Application number: 2025/92713	
What is the application for?:	Reserved matters application pursuant to outline permission 2023/92079 for erect
Address of the site or building:	Rear of, 23 to 43, Moor Lane, Gomersal, Cleckheaton, BD19 4LF
Postcode:	LS10 1NB

User comments

Type of comment: An objection	
Do you wish your comments to be published on the website anonymously?	No

Polystorm Attenuation Tank 2
Plan View
 (Scale 1:25)

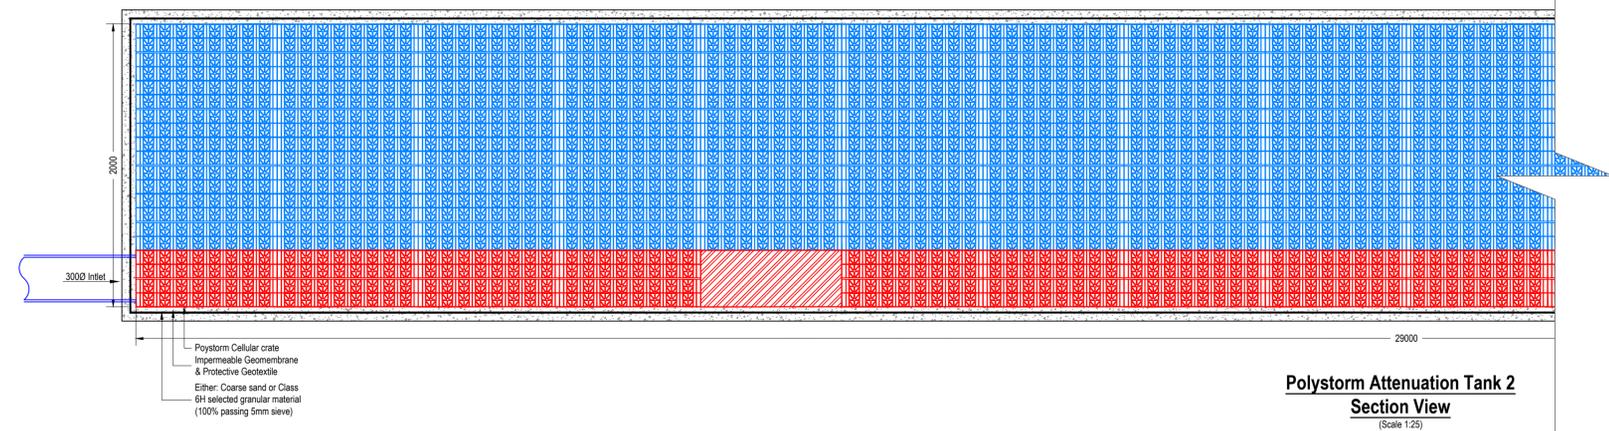
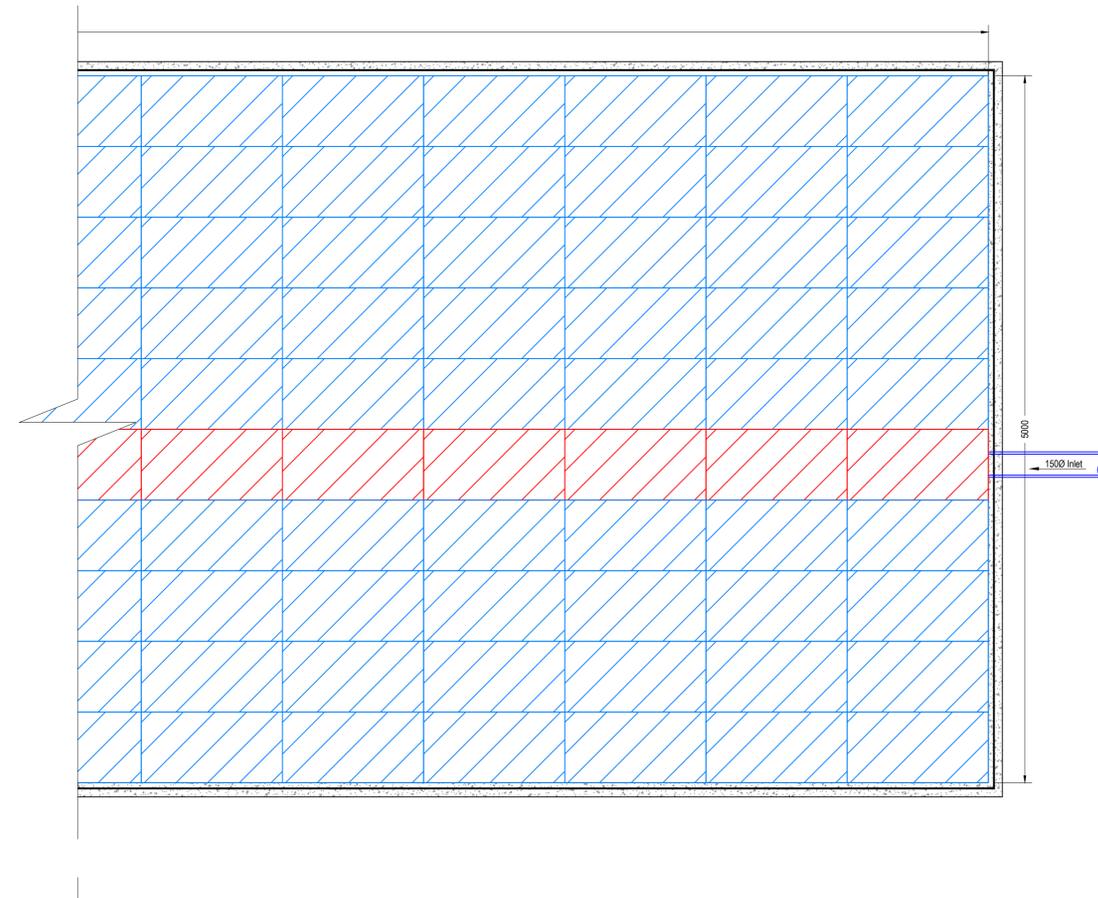
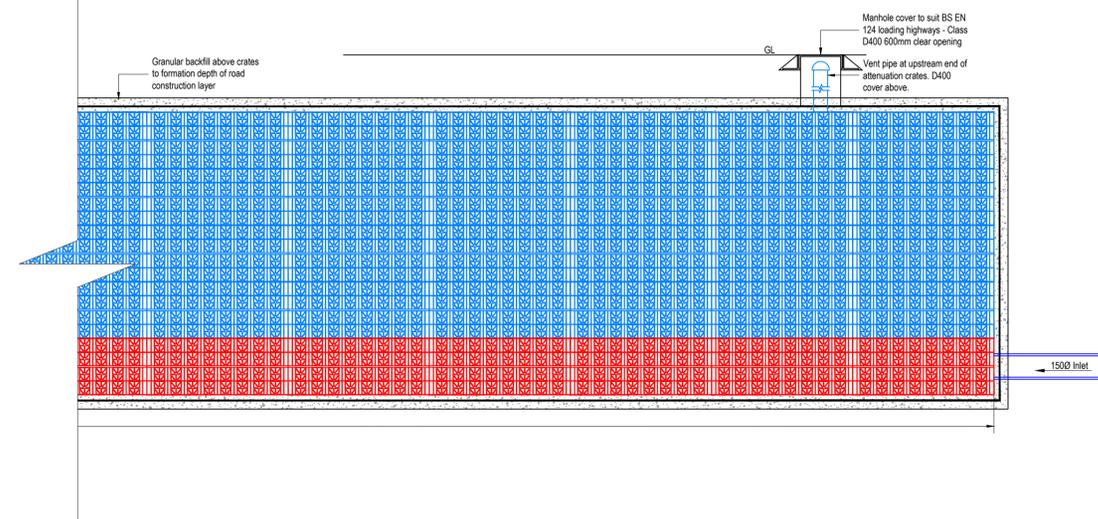
This drainage plan shows plastic crates located in two locations. The developer is channeling surface water down the site via these crates, towards existing residential properties. We are extremely concerned as to whether a 6 inch pipe will have enough capacity to carry combined foul sewerage and surface water, to a drain in Moor Lane. Failure of this pipe would be catastrophic for all the residents in the local vicinity.

Private Drainage

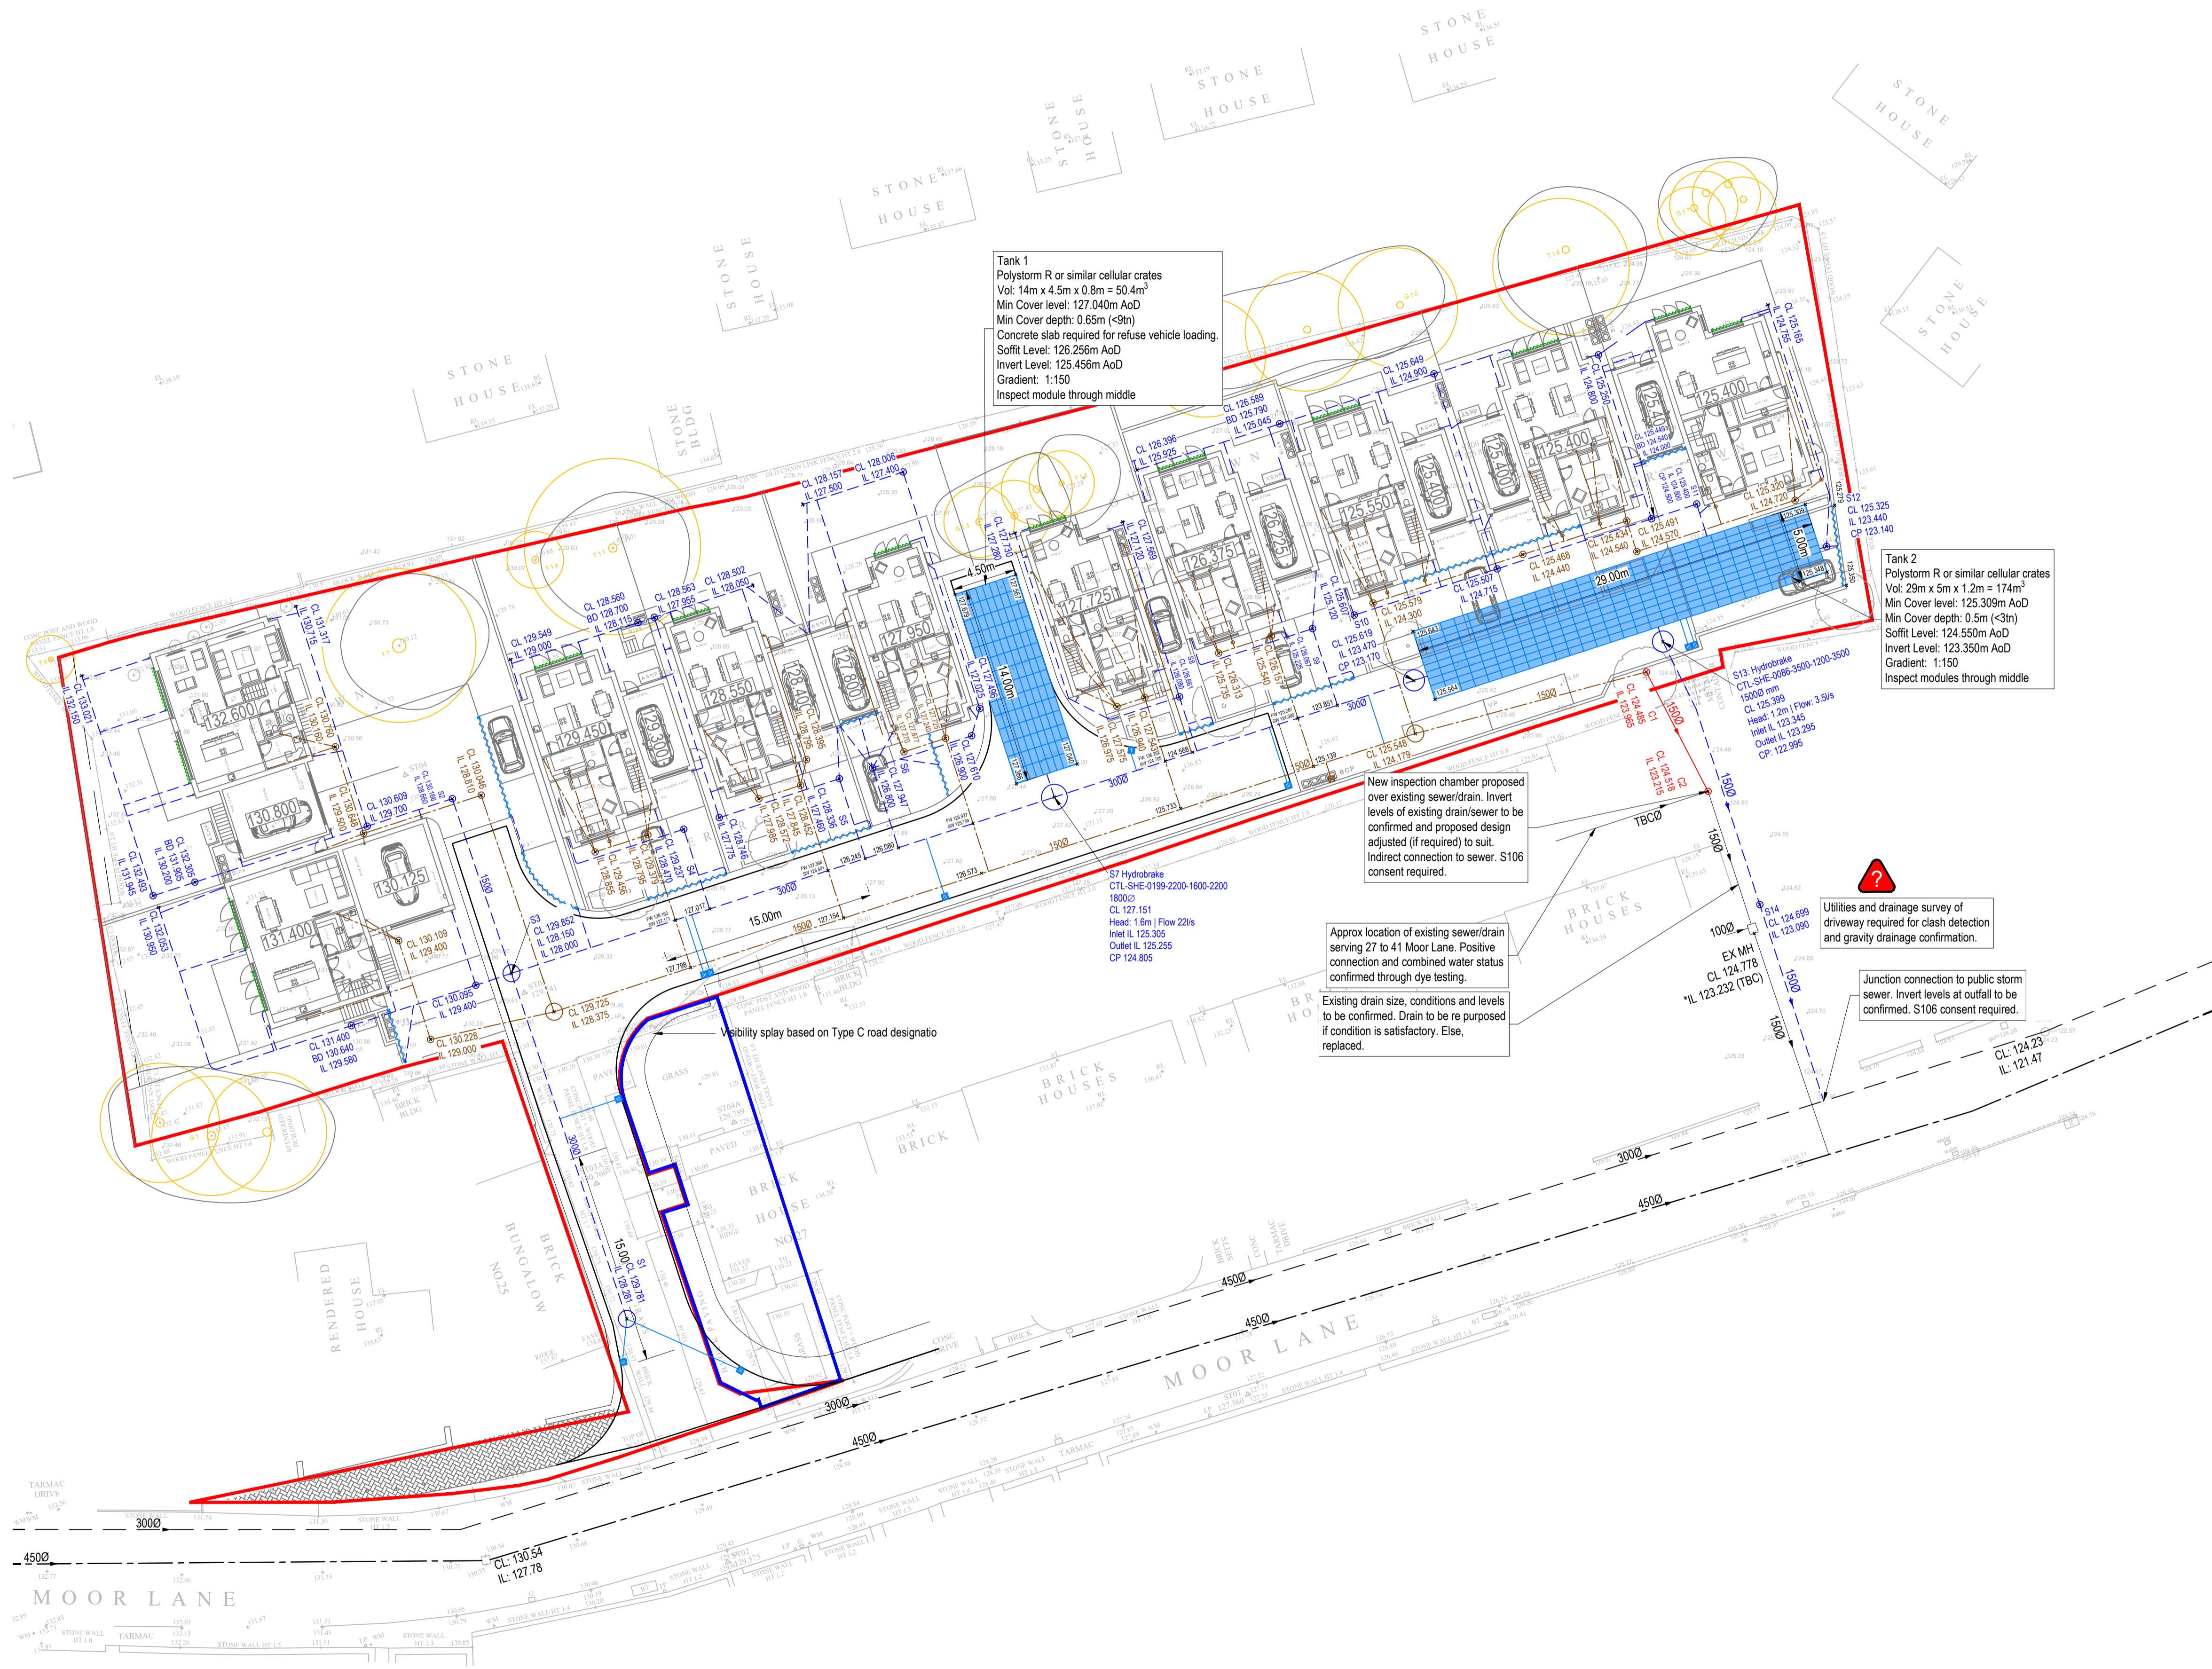
The Drainage Plan states: "Junction connection to existing combined sewer. No other sewers present in the road (contrary to YW Mapping). S106 consent required. Invert level to be confirmed. Levels shown are inferred between manholes along Moor Lane only."

Yorkshire Waters website states "Please note that foul water must not be disposed of to a surface water sewer and surface water should generally not be discharged to a foul or combined sewer." This plan is discharging both foul and surface water into what is believed to be a combined sewer in Moor Lane.

This drainage plan will not be sufficient to cope with current and future surface water and foul water and a '1 in 100 year storm event.' Any excesses will result in flooding and drains being overwhelmed.
